OBJECTION CM/64/19/PL Langford Horsemere Green Lane

Planning Objection: CM/64/19/PL Langford, Horsemere Green Lane BN17 5QZ

Drg No: 190725/SL-01
Rev: K

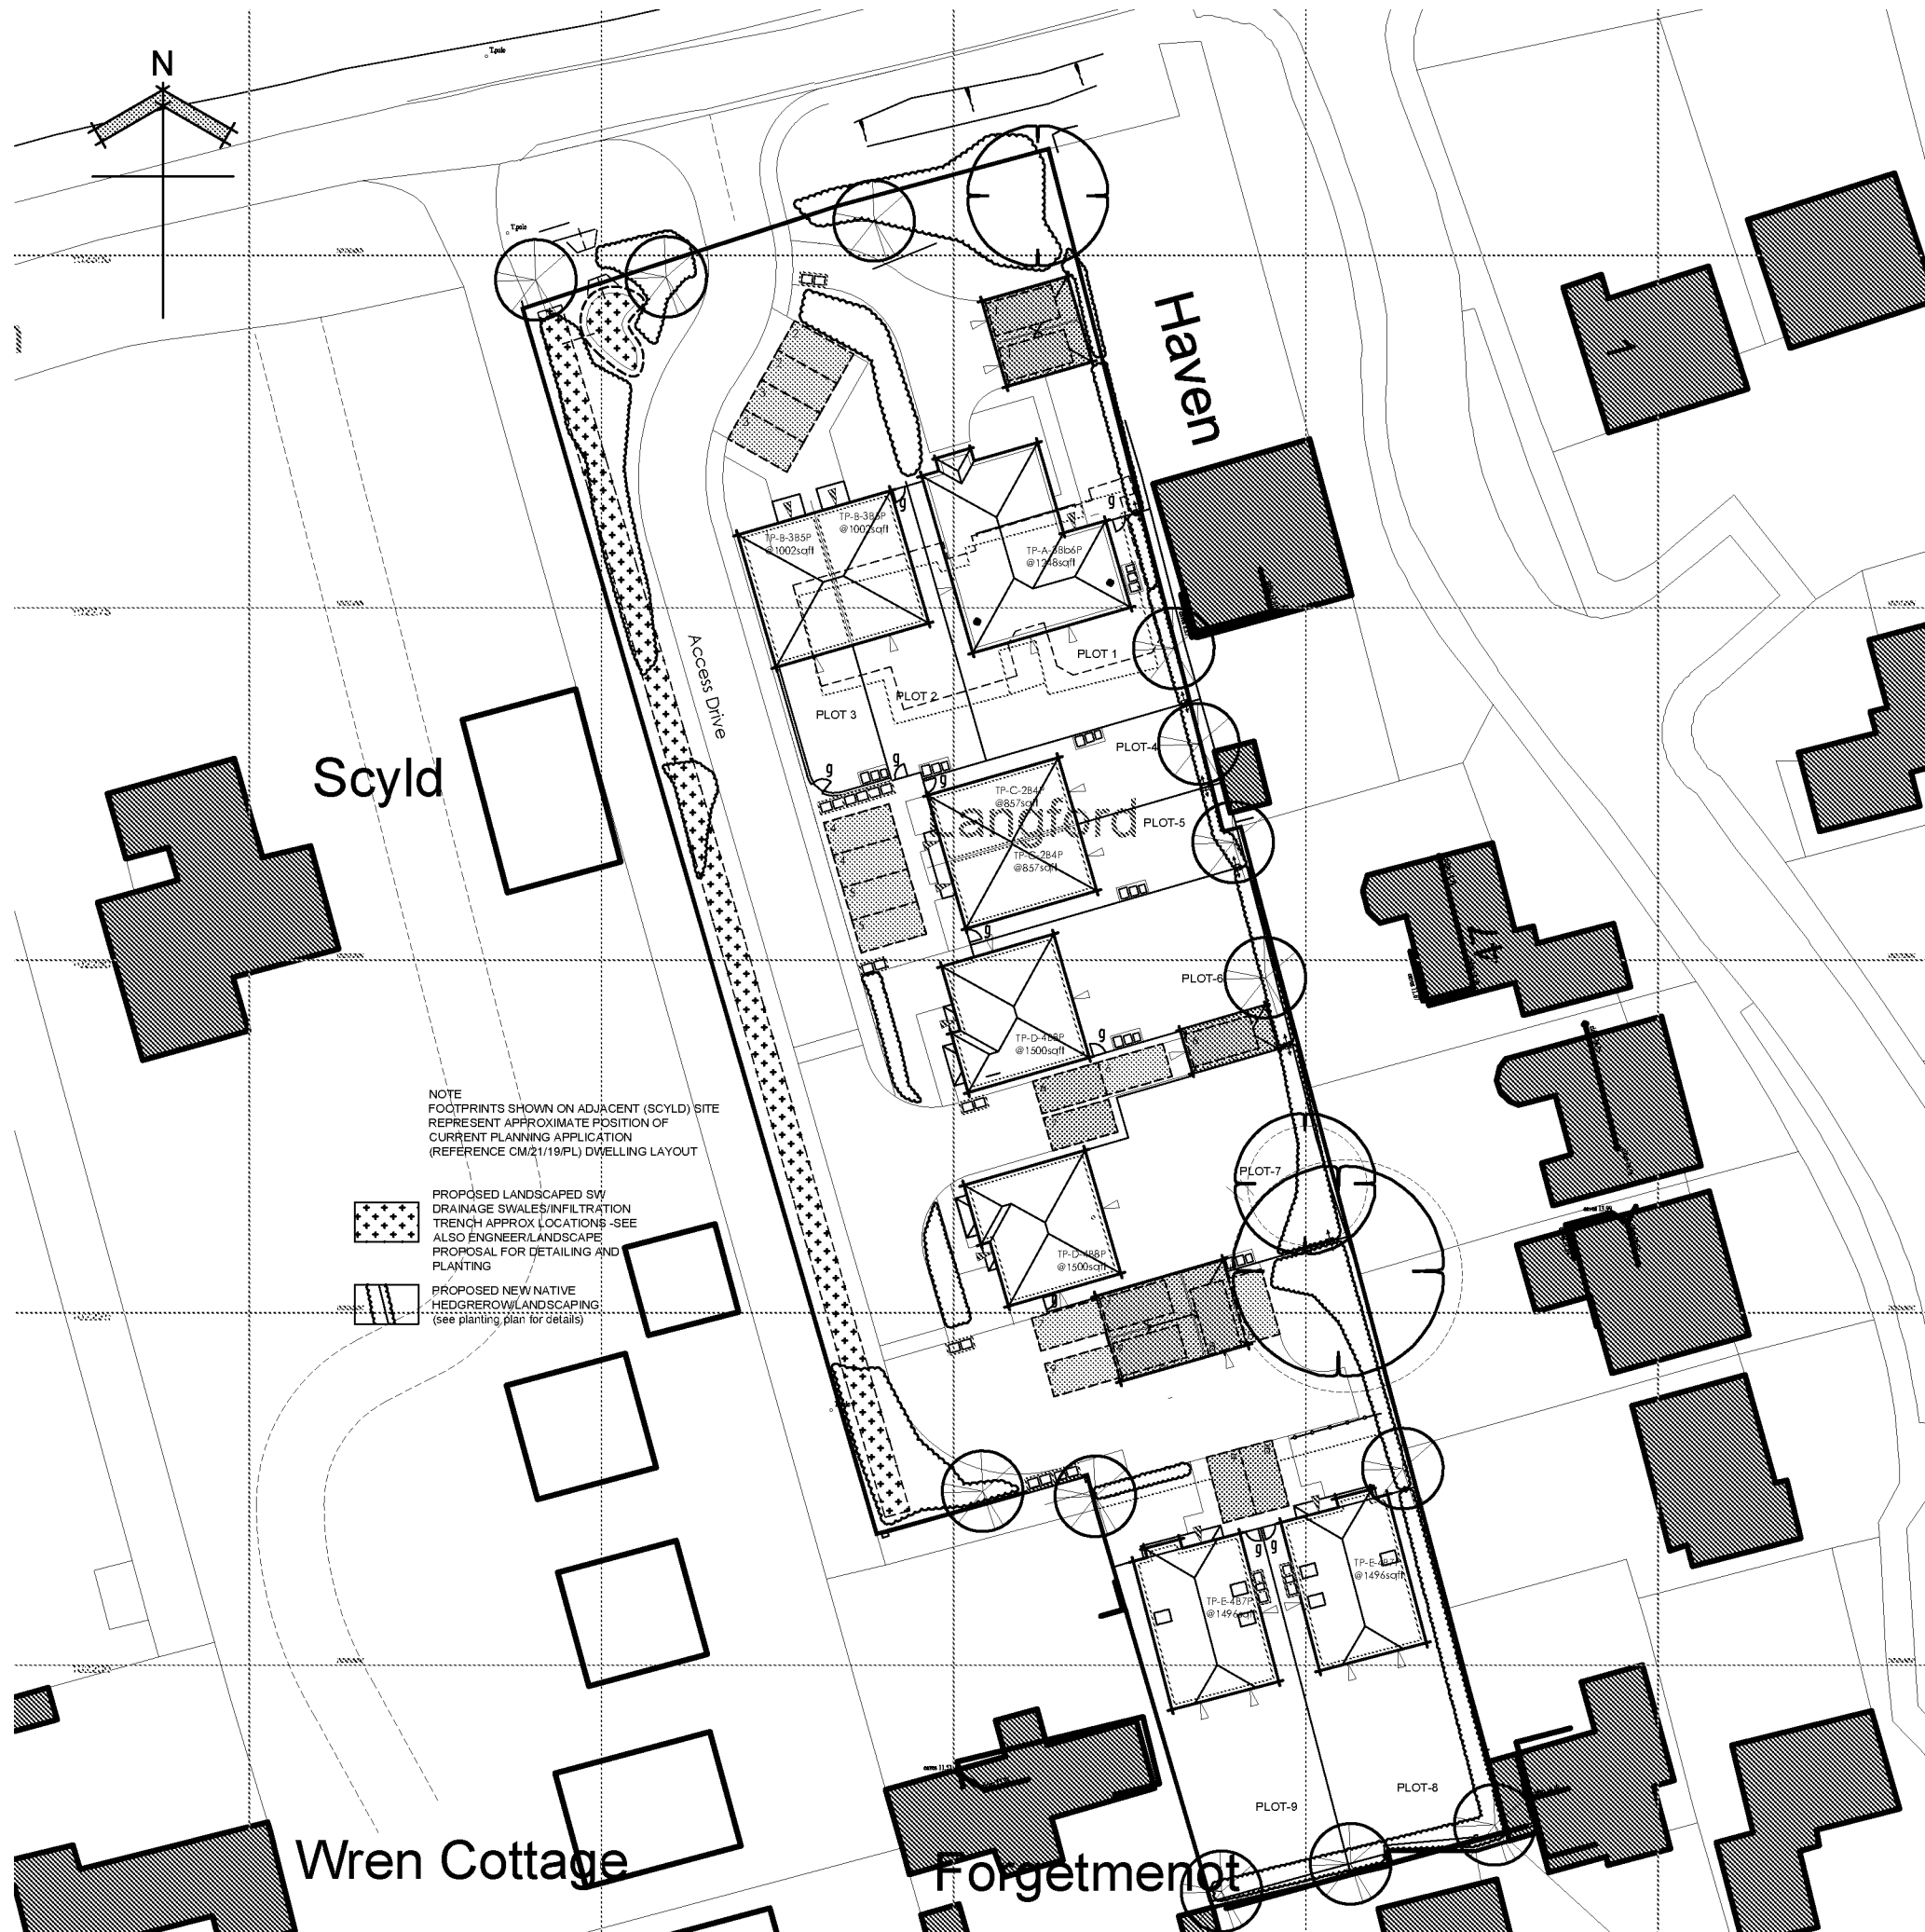
3. The value of my property has been badly affected.
4. PLOT 8 runs the length of my boundary. An application for a 4-bed house type E has been superseded by House type F described as a **3-bed BUNGALOW**. Having looked at the plans this is a **HOUSE** with 2 bedrooms and 2 bathrooms on the first floor, and one bedroom on ground floor. The whole length of the proposed house runs the whole length of my boundary, with permanent structure within feet of my fence. This is very intrusive, and will obliterate light for the majority of the day, completely unacceptable. I speak on behalf of myself and my affected neighbours.

6. If the applicant were to reduce the roof height to single storey, ie, that of a bungalow, as proposed, and lower the ground level, this would fall in line with their proposal of '**2 x 3-bed bungalows**' made to Arun District Council.

7. I am also objecting to any trees being planted within proximity to my boundary. These will be a nuisance which will also create light issues, roots; sap nutrients from soil, and create a mess with leaf drop etc.
